**To:** Molly McGuire  
**From:** Gary Upper  
**cc:**  
**Date:** 11-6-23  
**Re:** SUB23 Tree Replacement Comments

Here is a summary of the tree replacement requirements on this short plat and a landscape plan that goes with the comments.

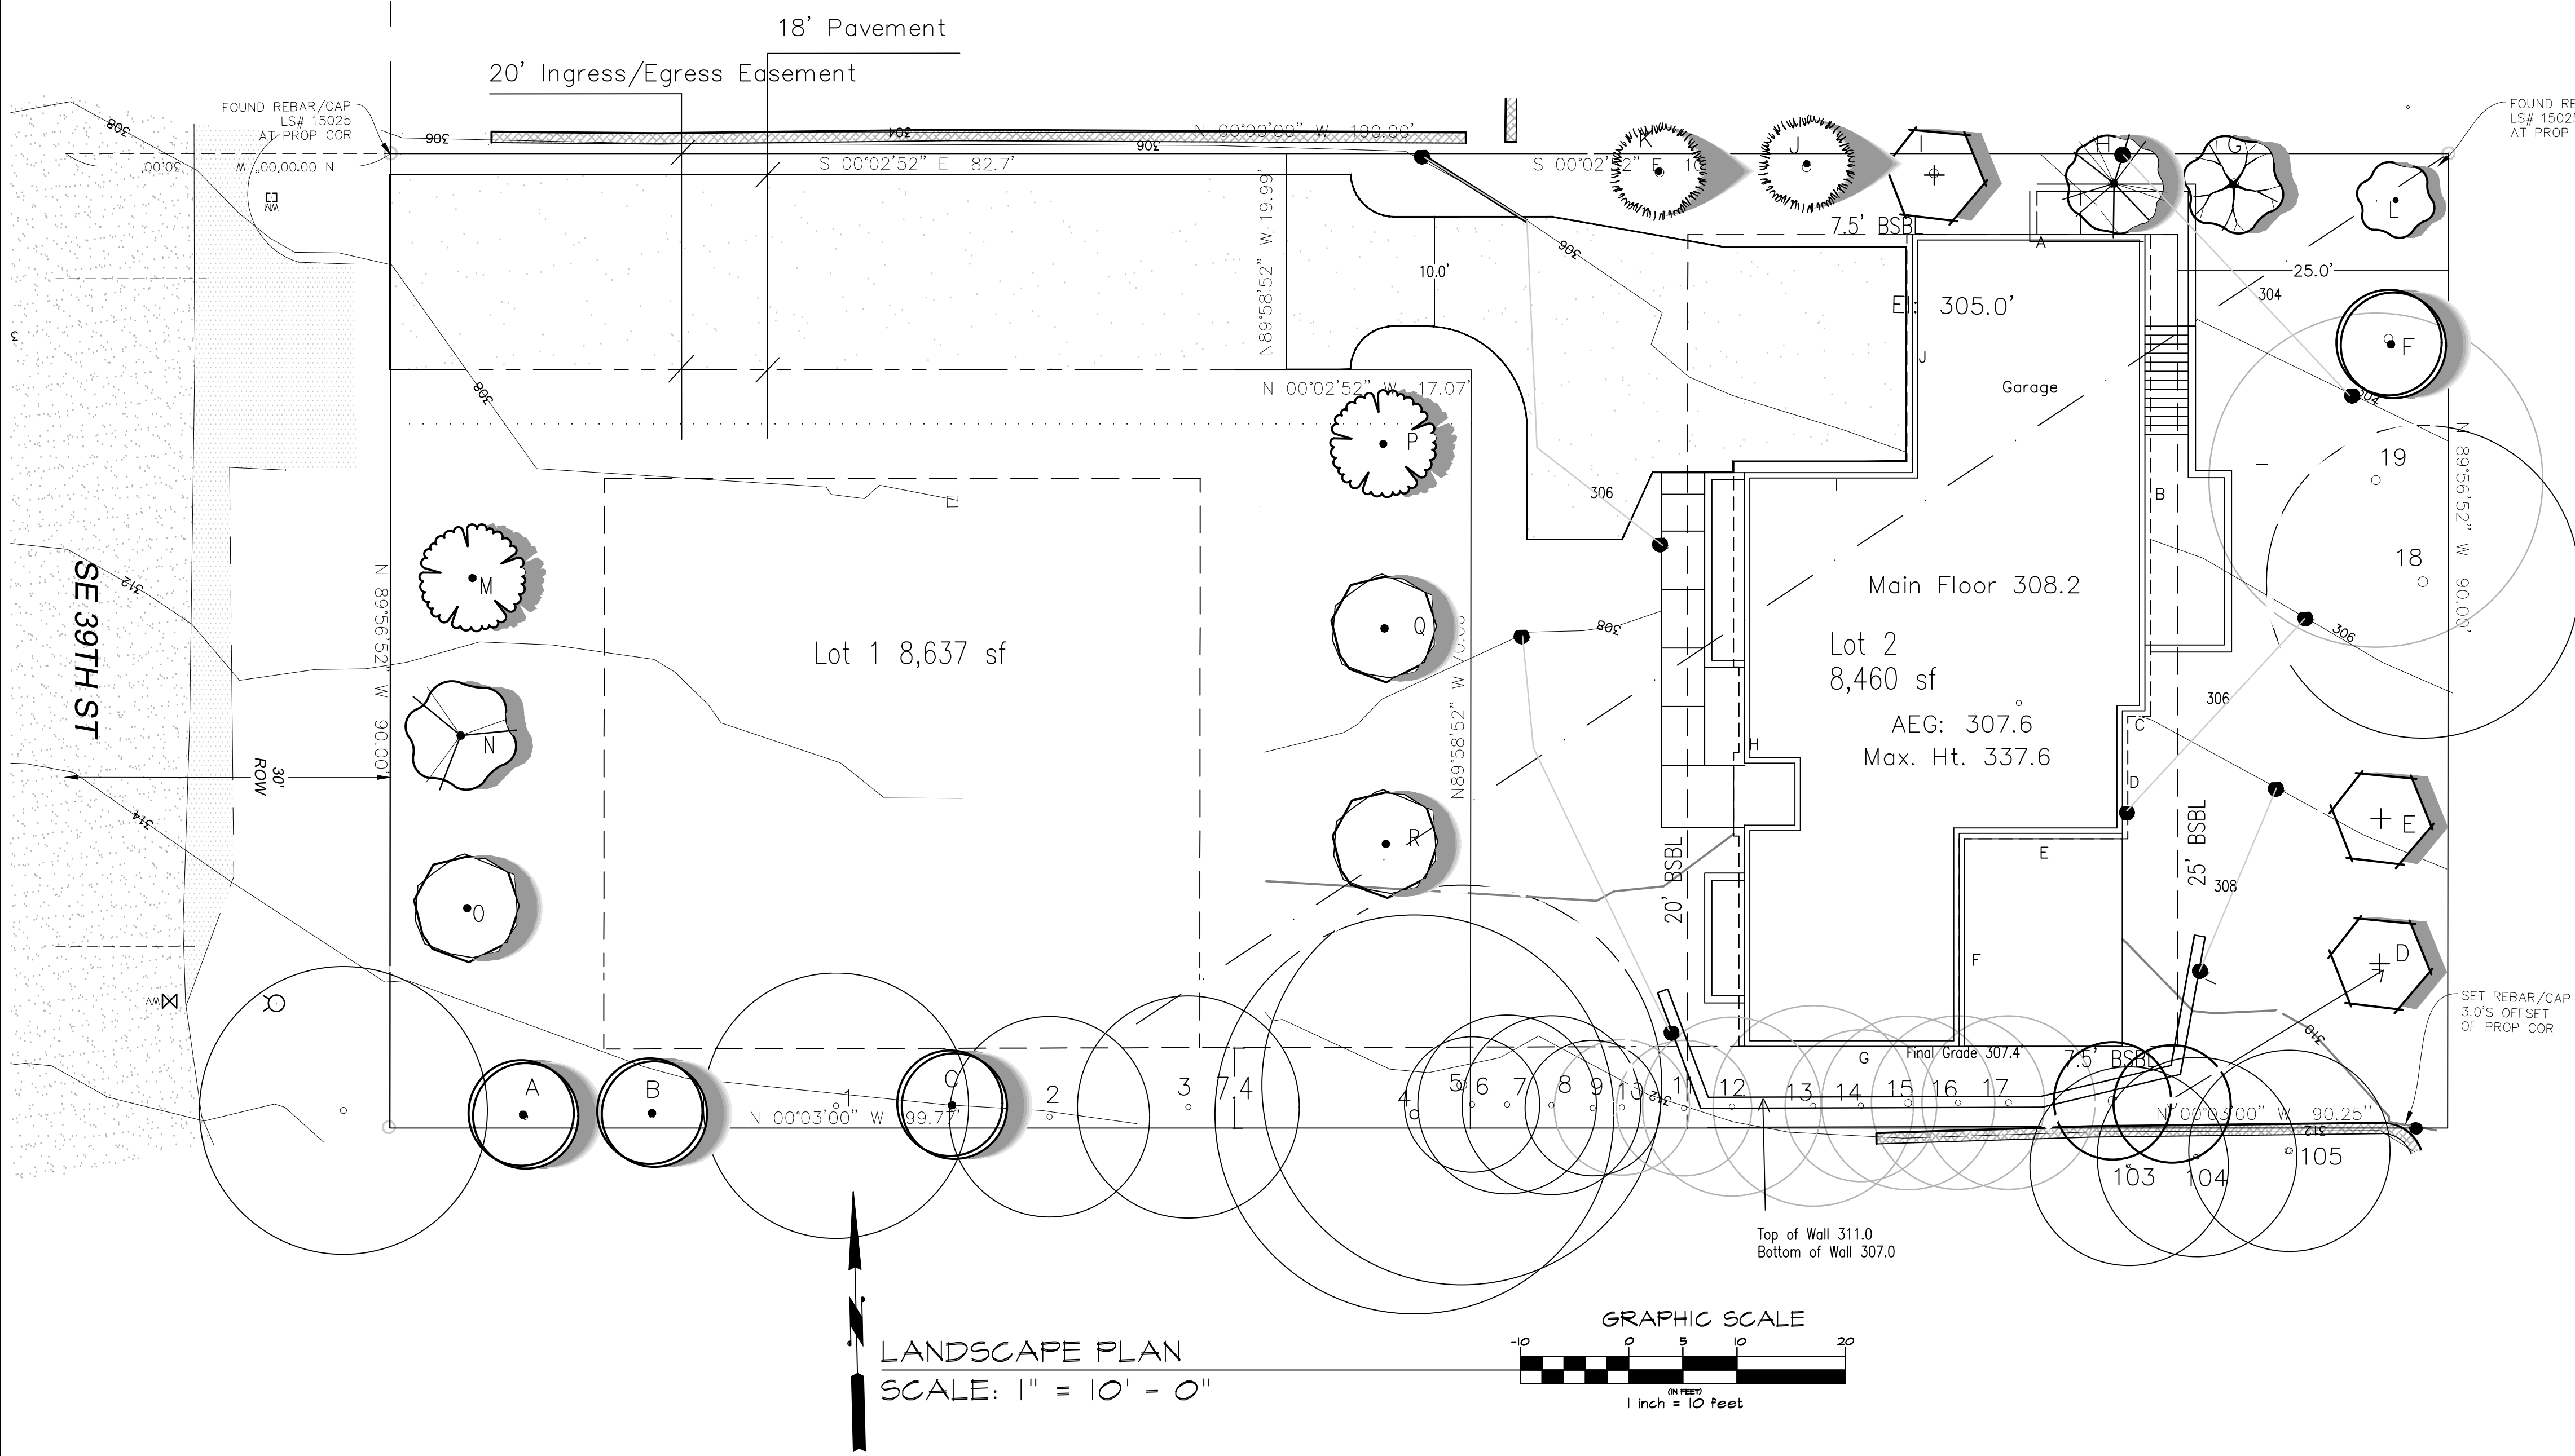
1. On a previous tree replacement permit, the previous owner of this property needed to provide 12 replacement trees. As always, 50% of those trees needed to be taken from the native species list. It turns out that none of those trees were from the list. So the first requirement here is that we need to replace 6 of those trees with the correct specie.

2. Our new short plat proposal also coincidentally requires 12 replacement trees. We only have room to fit in an additional 6 trees beyond the 12 that were already planted (and swapped out). The remaining 6 trees will need to be covered by a fee in lieu of payment agreement.

3. The attached landscape plan shows the 6 trees being swapped out with 6 of the previously planted replacement trees and then it provides 6 new replacement trees per the above comments.
